**From:** [Molly McGuire](#)  
**To:** [Michele Lorilla](#)  
**Subject:** RE: 2207-019 Strand Permit  
**Date:** Thursday, November 17, 2022 9:53:00 AM

Again, the question is regarding the existing rockery on the site and whether mitigation of a marginally stable rockery (as discussed by the project geotech in their report) needs to be addressed or is it "grandfathered" in. Please see Don Cole's October 25<sup>th</sup> email for detailed discussion of the issue to be resolved.

*The geotechnical engineering report indicates "...due to the loose nature of the upper fill soils behind the rockery, it would only be considered moderately stable, and likely has a current factor of safety of 1.0 or slightly higher with regards to slope stability."*

TOPOGRAPHIC & BOUNDARY SURVEY
PARCEL NO. 9350900620

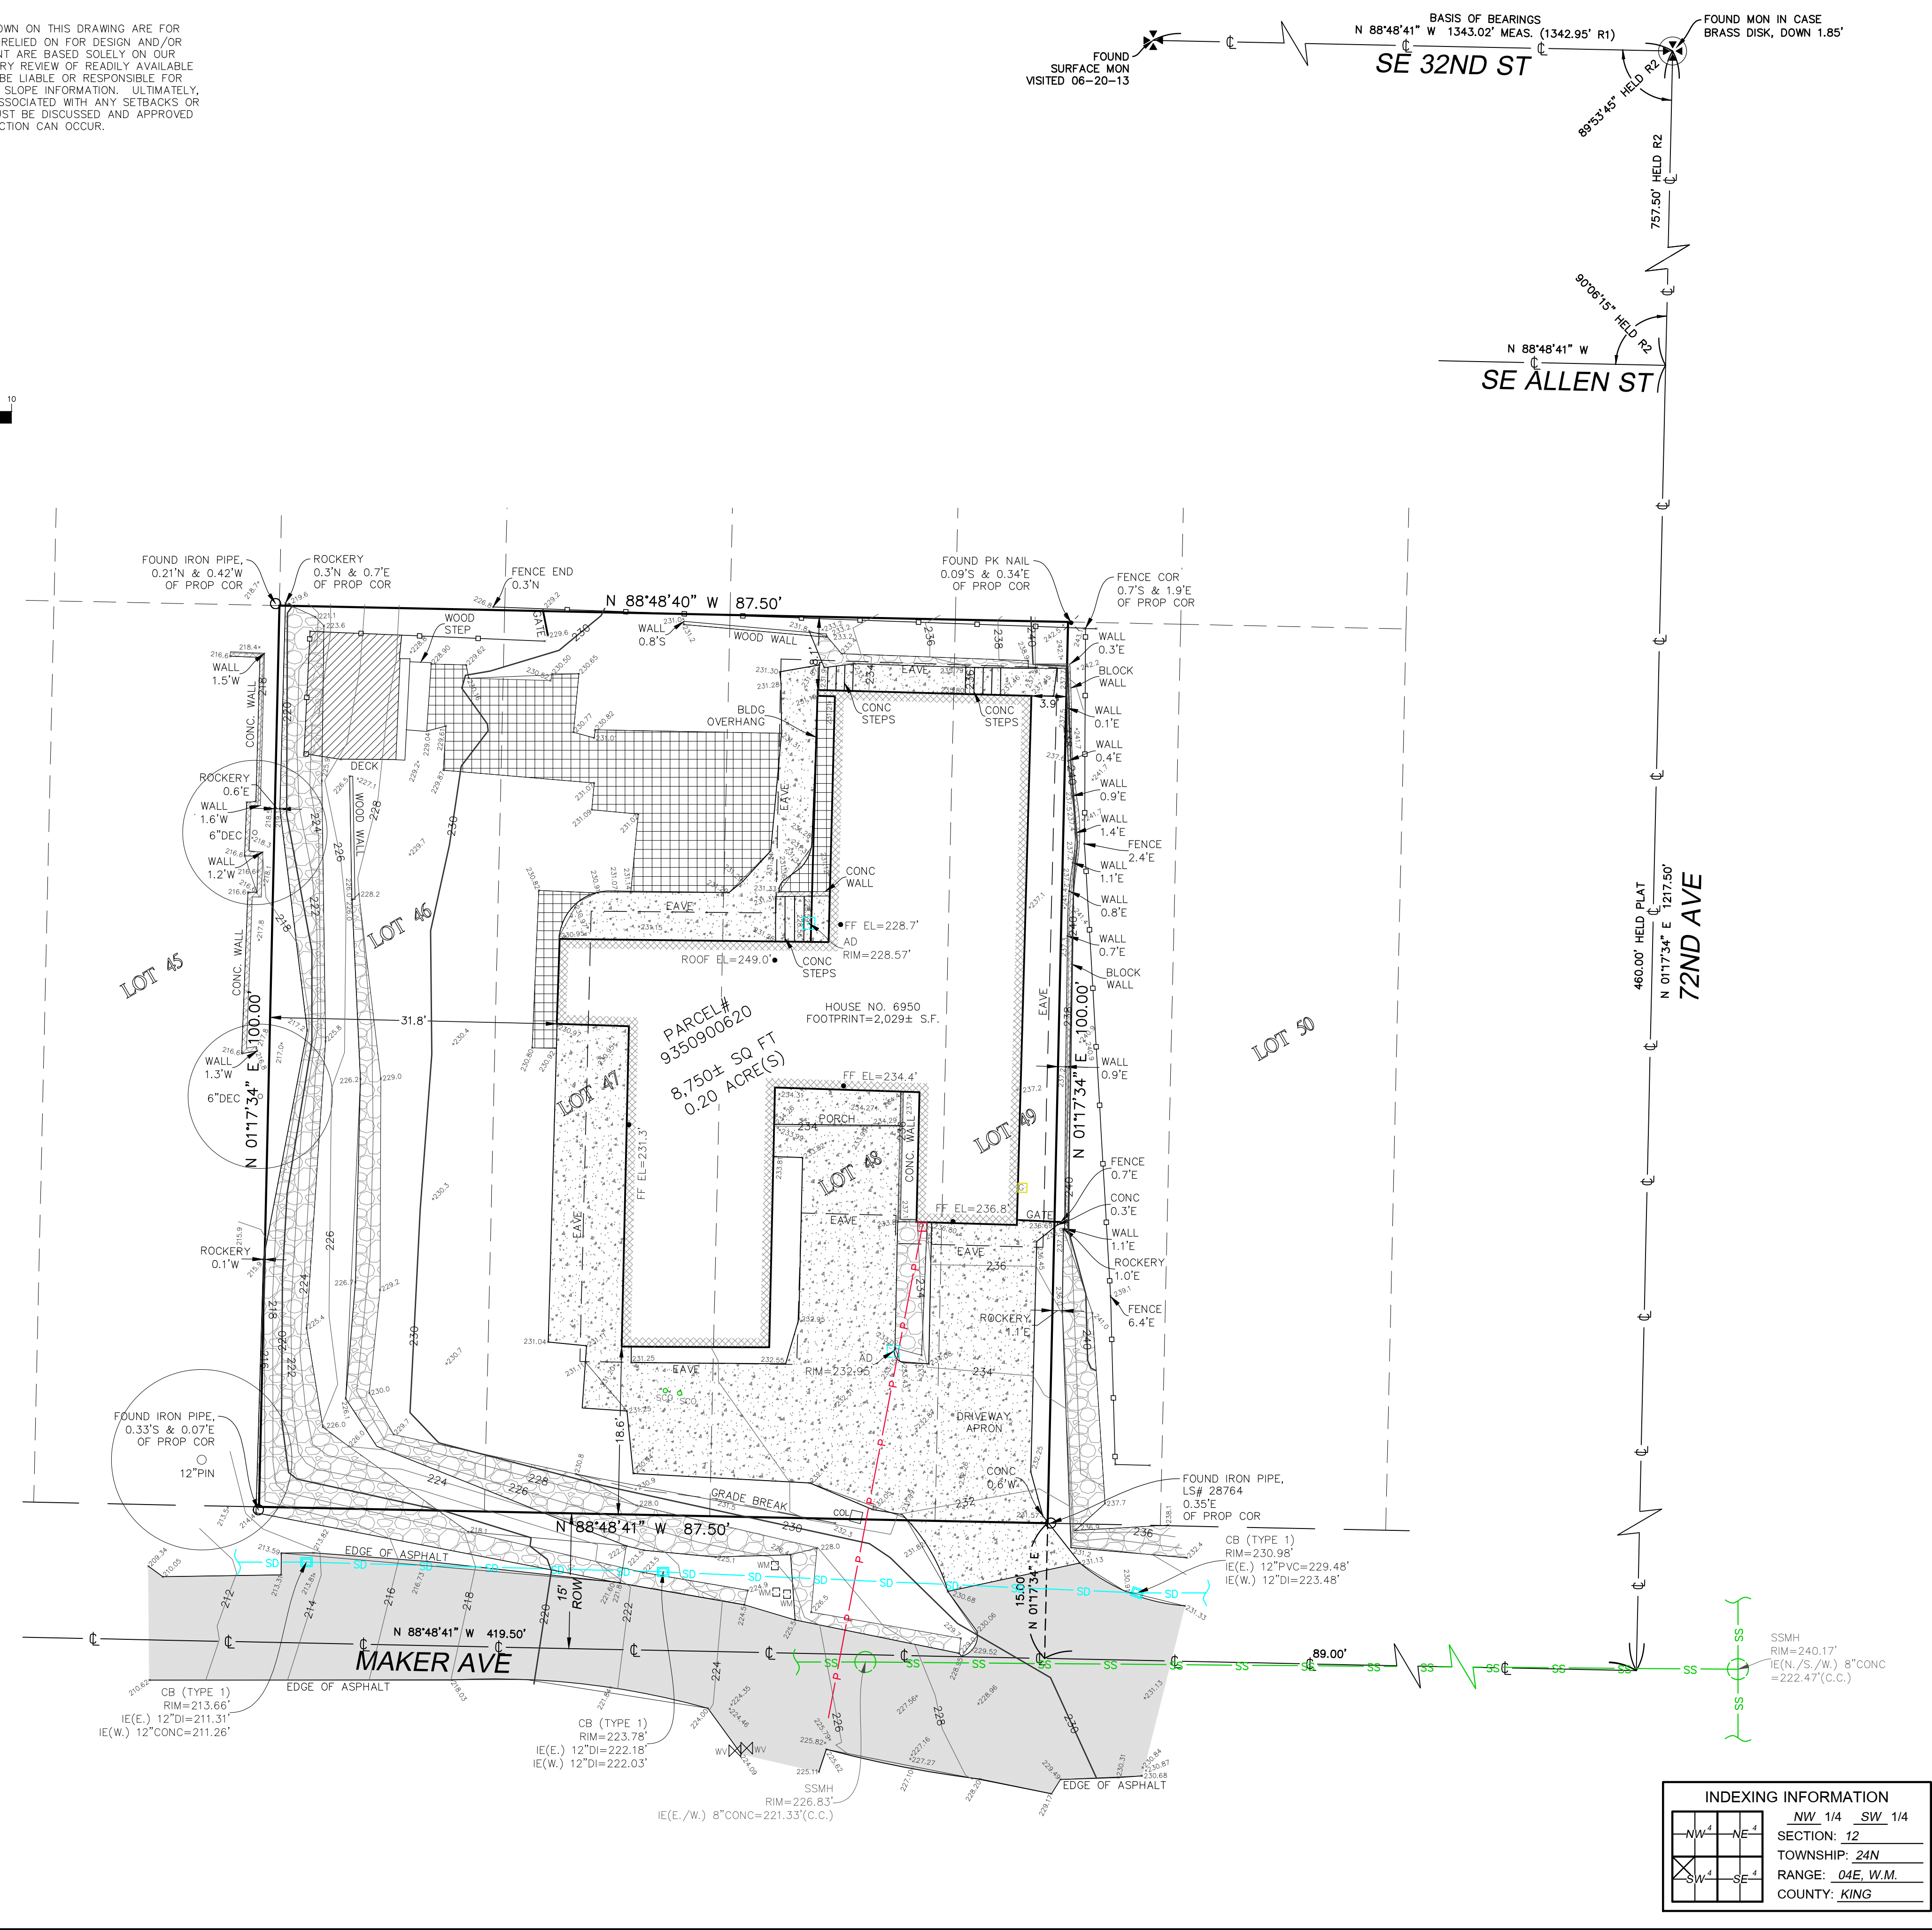
I think the issue is that the rockery is substandard to begin with and the geotechnical engineer has noted a marginal stability (no stability analyses were given, but rockeries are not used to retain a fill since they are not considered retaining walls). Also the fact that the fill is loose indicates no compaction during original placement of this fill—so this fill would be considered an uncontrolled or unengineered fill. Since this has been noted by their geotechnical engineer, it is my opinion that there has to be some mitigation.

*Indicate how this hazard is being mitigated (MICC 19.07.160).*

Although the new site development is not "touching—altering" the existing rockeries (except for utilities that may be incorrectly located on the civil drawings) does this statement in the report identify a hazard that then has to be mitigated? FS of 1.0 is not the standard for long term stability—not to mention the use of rockery to retain a loose fill.

Quite a few of the neighbors are concerned about the rockery. Per the conversations below, go ahead and have them do mitigation of the rockery.
